Attachment 1: Department's Comments on EIS

Project Description

Drawing Title:
Landscape Plan
DWG No:

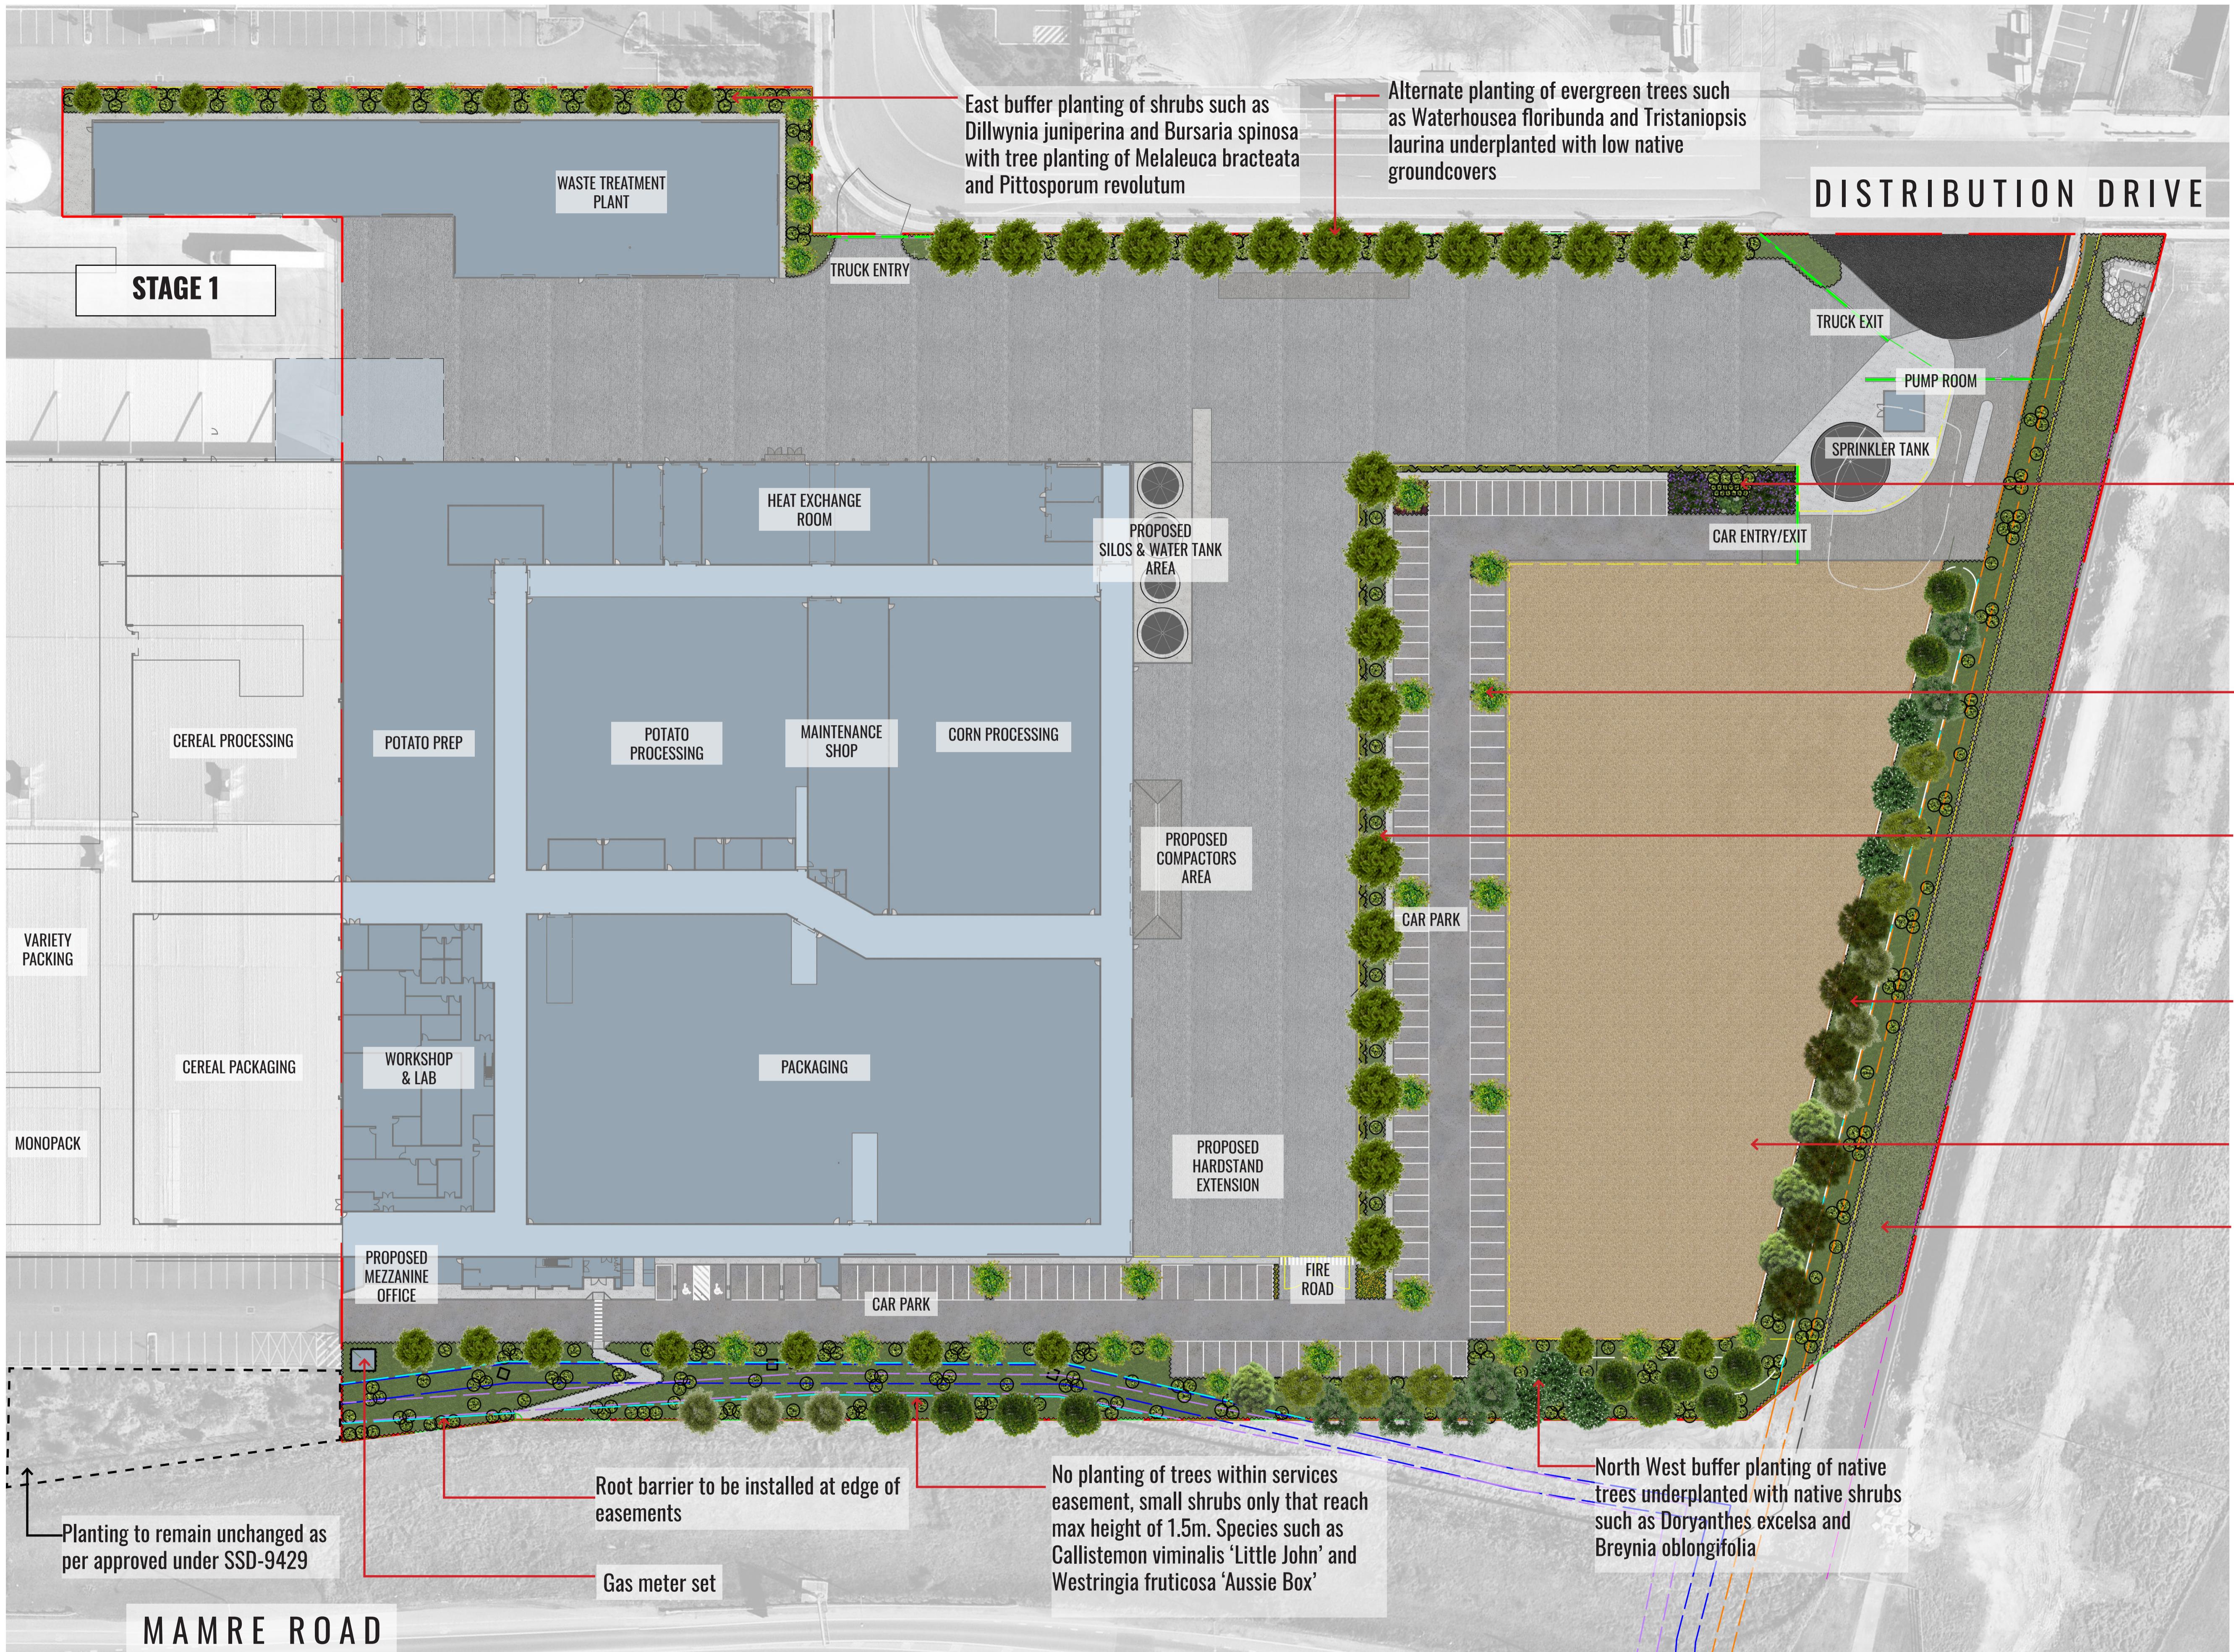
- The northern boundary of the site is proposed to remain undeveloped as residual land for use as temporary truck parking and the EIS stipulates the residual land is not included as part of this SSD application. However, this contradicts the Architectural Plans and Landscape Plans which indicate the residual land will be used as an erosion and sediment control basin during construction and layered with compacted aggregate to engineering standards to sustain truck parking. Please confirm whether development consent is sought for works within and use of the residual land for heavy vehicle parking.

- Should use of the residual land form part of the SSD, justification should be provided for the proposed use. If the residual land temporary truck parking is not intended to be proposed under this subject SSD application, updated documents including plans and the Traffic Impact Assessment should be provided to remove all reference to its use and construction as it can not be considered under this subject application.

ENTRY (B-DOUBLES)

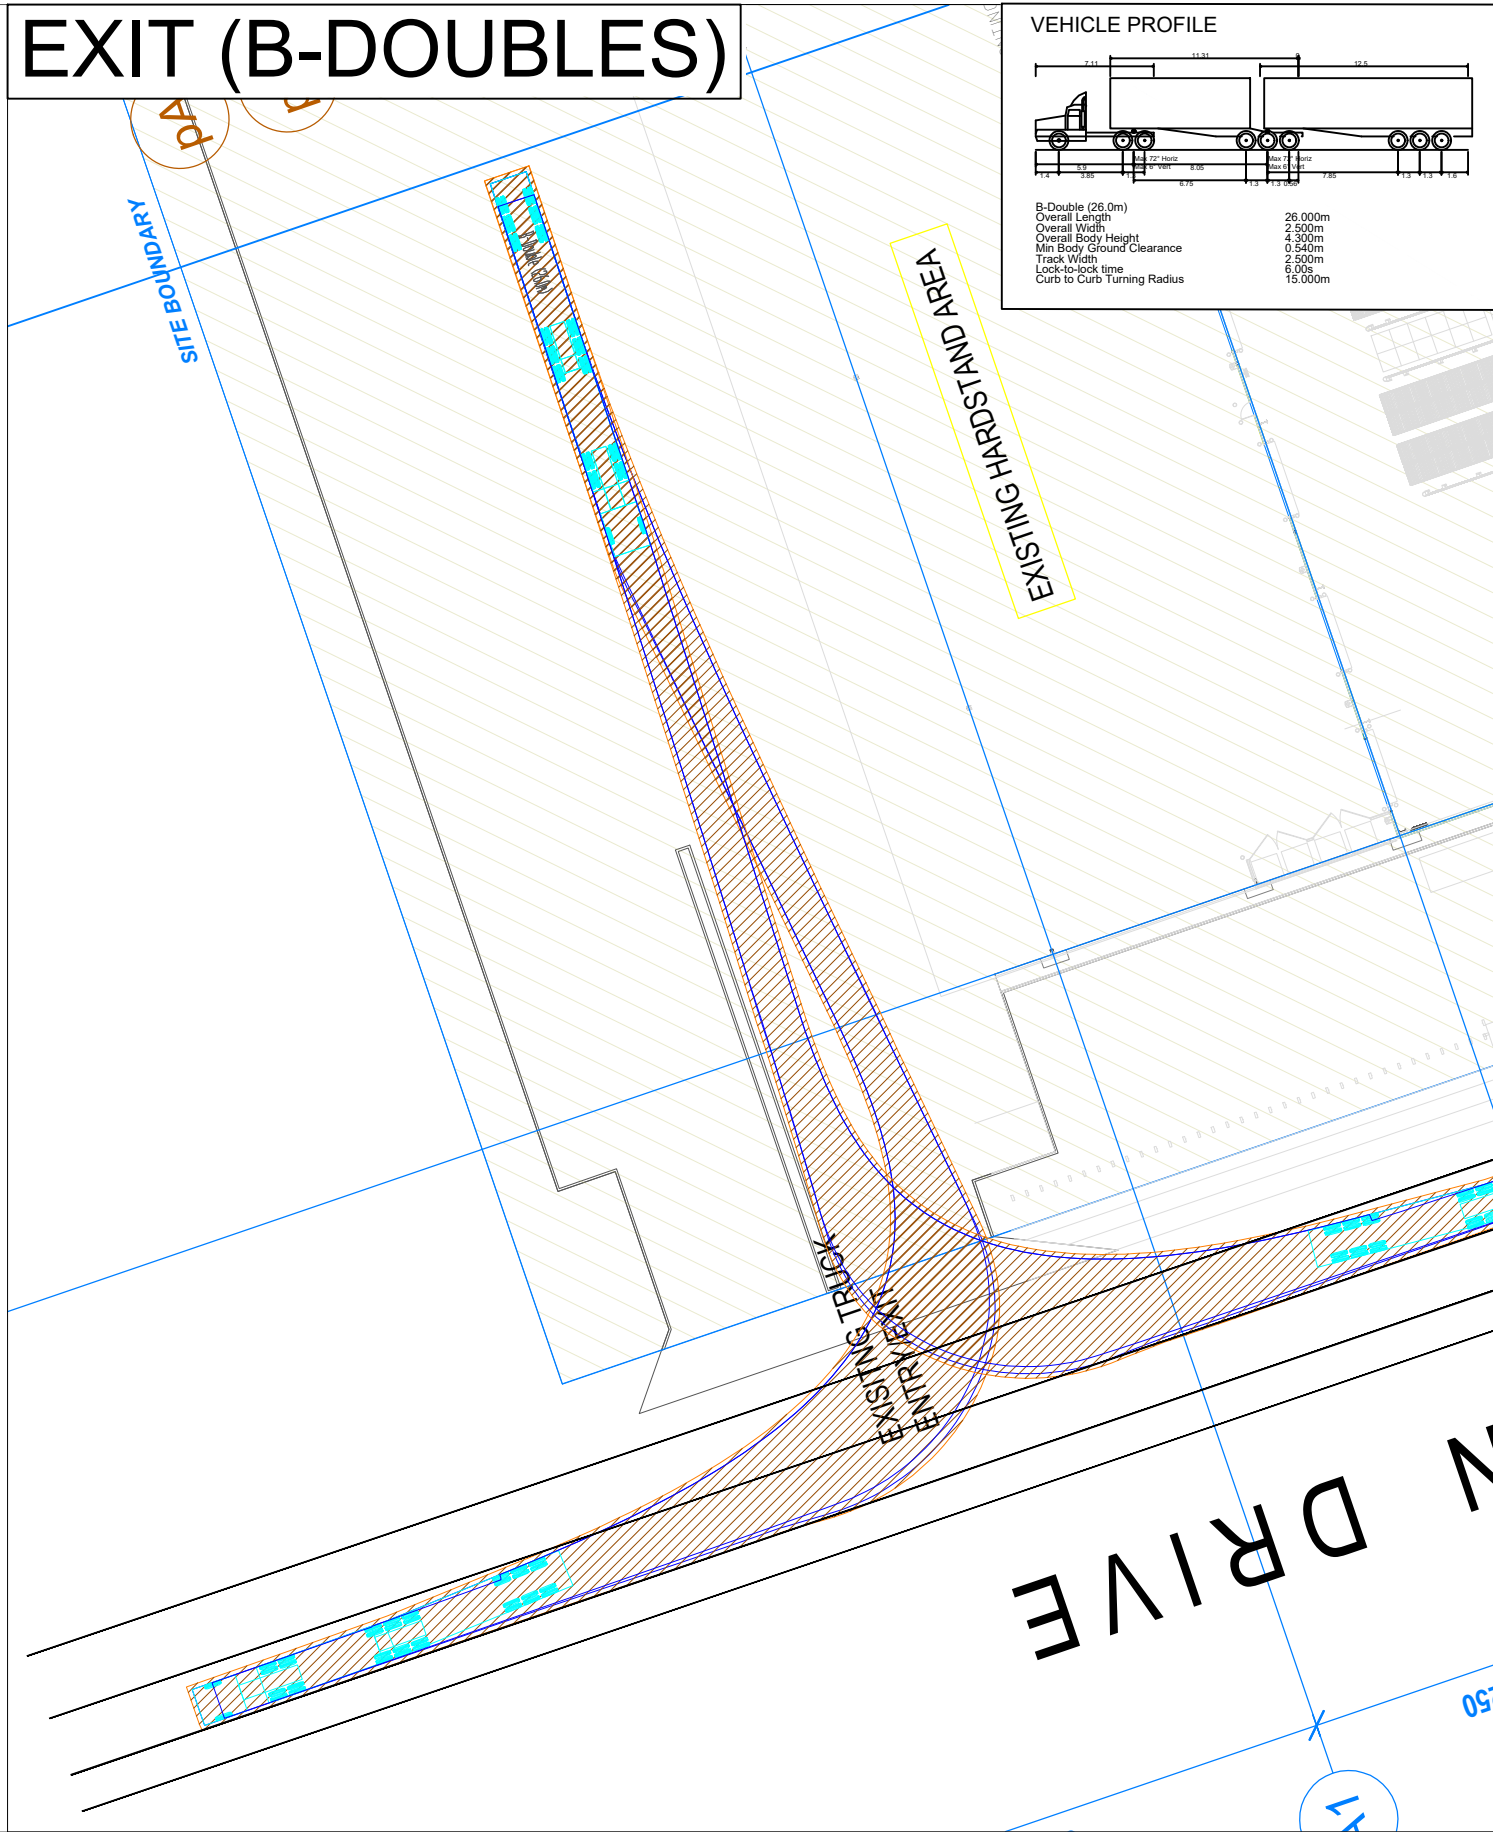
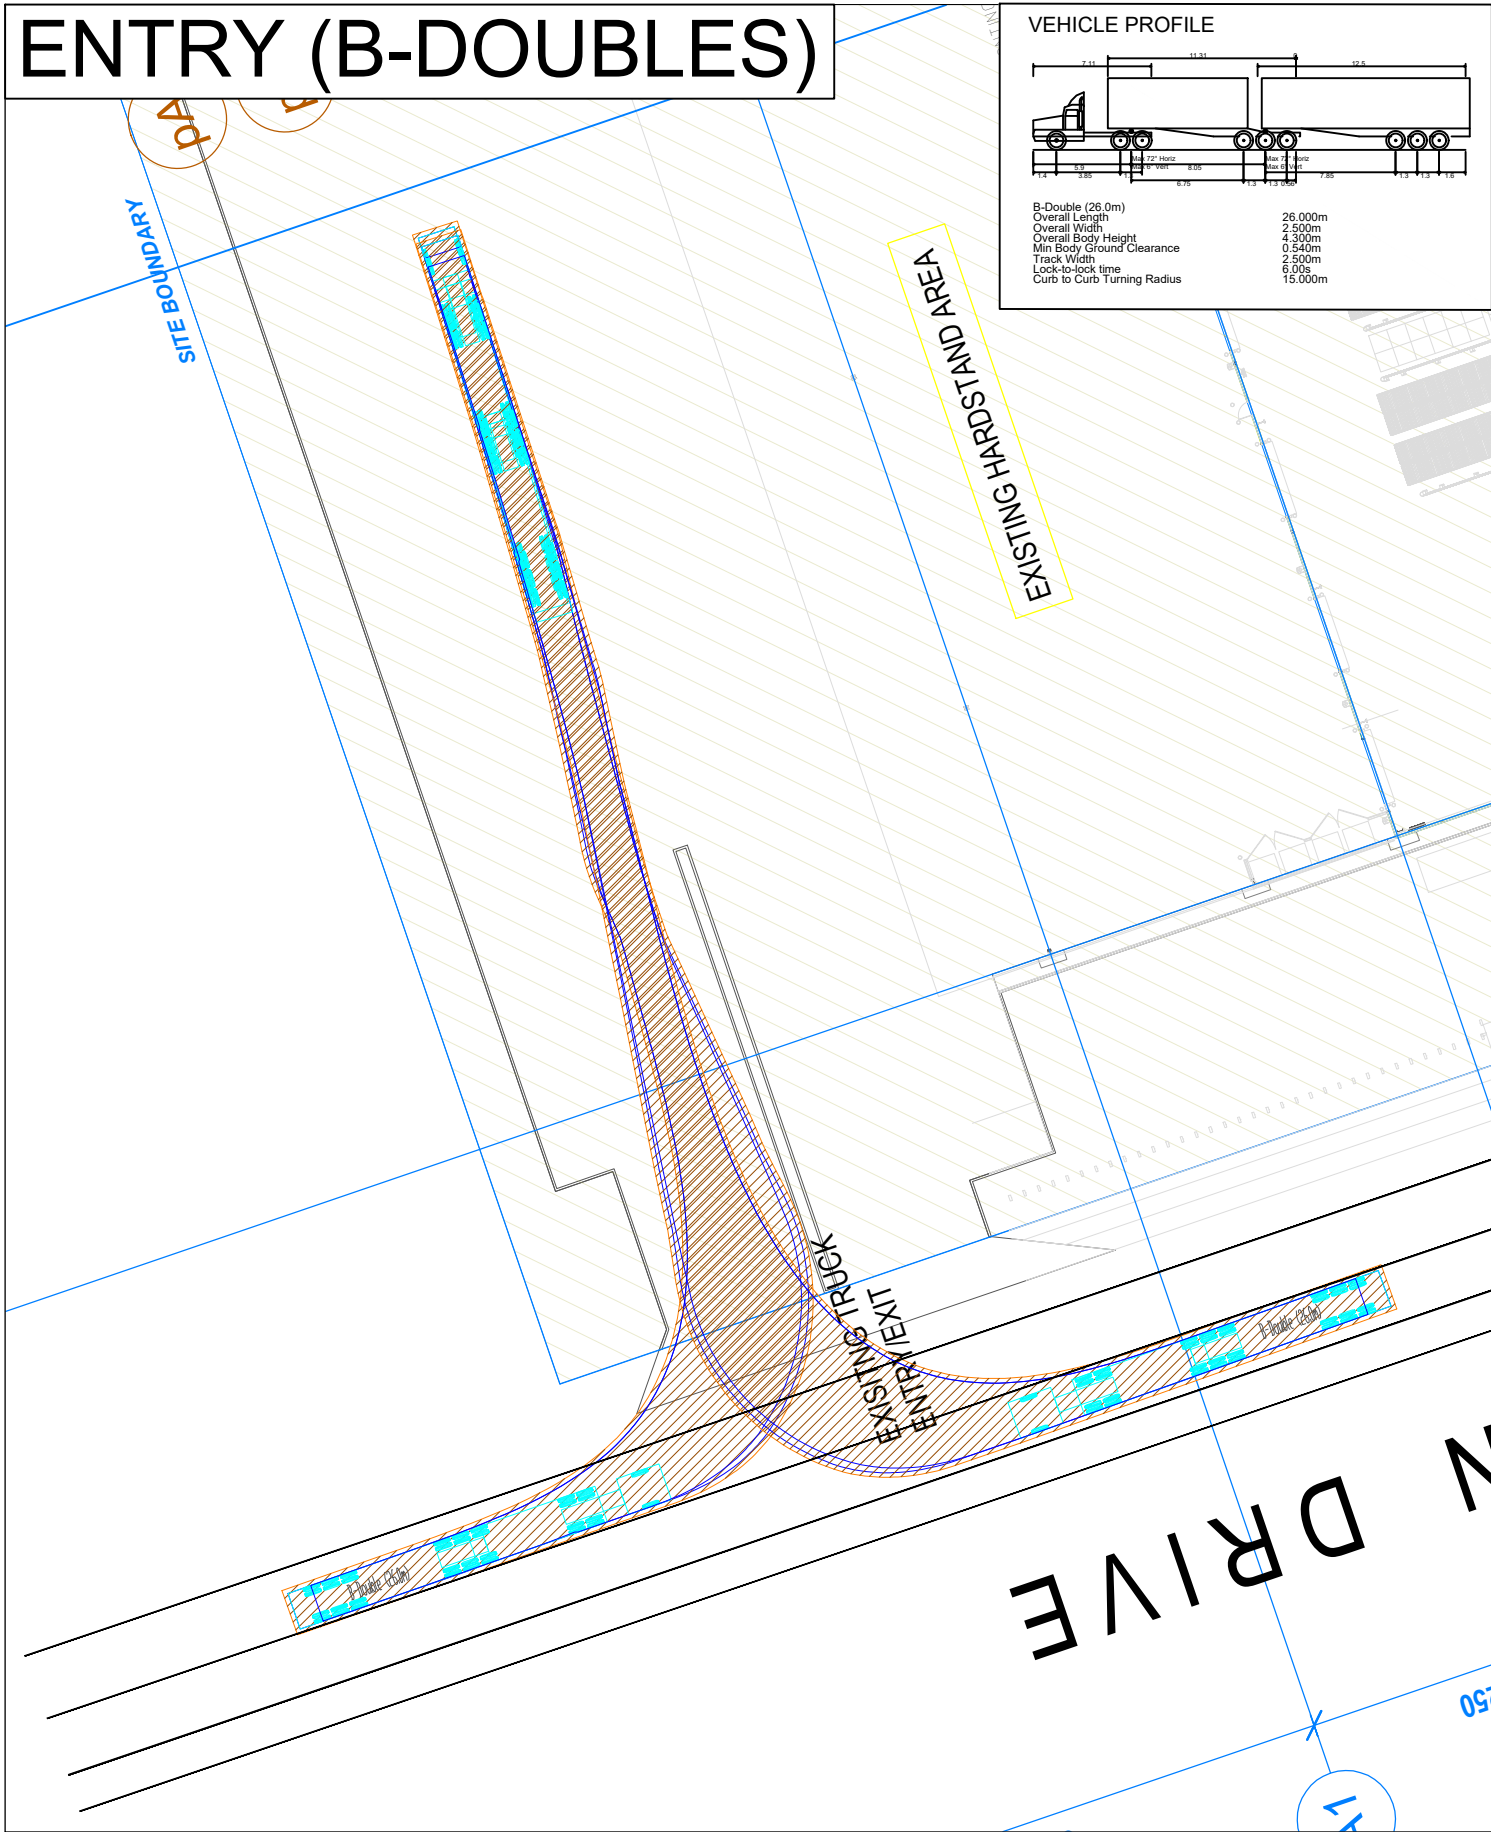
- As mentioned above, the Department notes the development operations will include the delivery of products and materials such as oils and flours to the manufacturing facility. However, the SWEPT path analysis drawings provided only demonstrate the vehicle movements of raw potato and corn material delivery to the site. The Department requests further SWEPT path analysis demonstrating the movements of all delivery vehicles to the site including the identification of distribution/delivery points on the site.
